NSW RURAL FIRE SERVICE

Your reference: SSD-11233241
Our reference: DA20201127004497-EIS & DA
Exhibition-1

State Significant Development – Educational Establishment
2 FAIRLEY ST MURRUMBATEMAN NSW 2582, 302//DP1228766

Figure 4: Bushfire Hazard Analysis and Asset Protection Zone

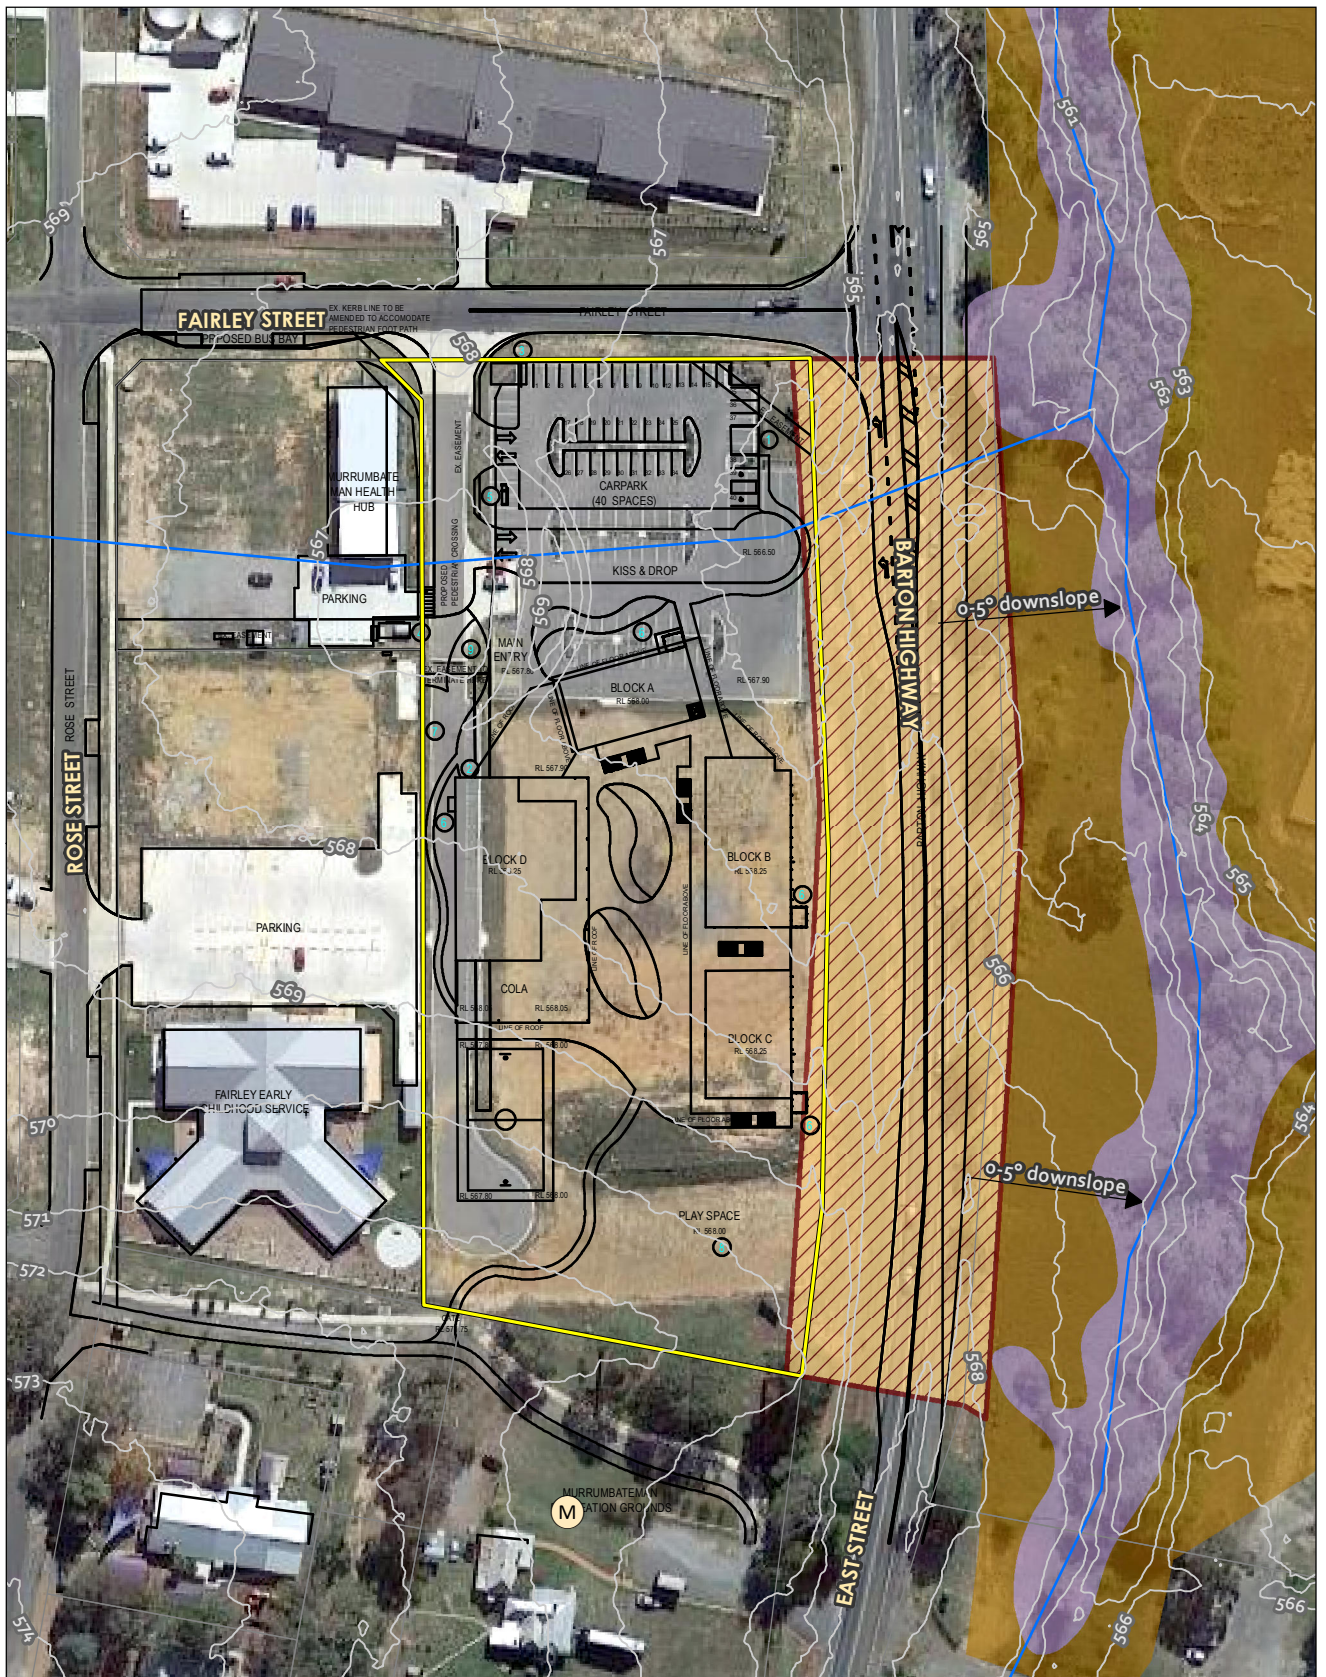
Insufficient information was provided with the application demonstrating the development can meet the provisions for Special Fire Protection Purpose development, as detailed in section 6.8 of *Planning for Bushfire Protection 2019 (PBP 2019)*. In particular, the asset protection zones required to achieve 10kW/m² (i.e. 40 meters) extend outside of the property boundary through the road reserve of Barton Hwy and into Lot 1 DP 1203828 in an easterly direction. It is assumed current maintenance strategies for Barton Hwy would ensure the road reserve would meet an inner protection area standard (Appendix 4 PBP 2019). Where the asset protection zone extends into Lot 1 DP 1203828 a suitably worded legal mechanism shall be created to ensure its management in perpetuity as an asset protection zone.

1. The NSW Rural Fire Service are unable to endorse the proposed development until one of the following are met;

Create a suitably worded legal mechanism over Lot 1 DP 1203828 to ensure the asset protection zone can be maintained in perpetuity as an inner protection area in accordance with Appendix 4 of PBP 2019.

OR

Revise the location of the development to ensure a 40 metre asset protection zone can legally be maintained in perpetuity on the eastern elevation of the development.
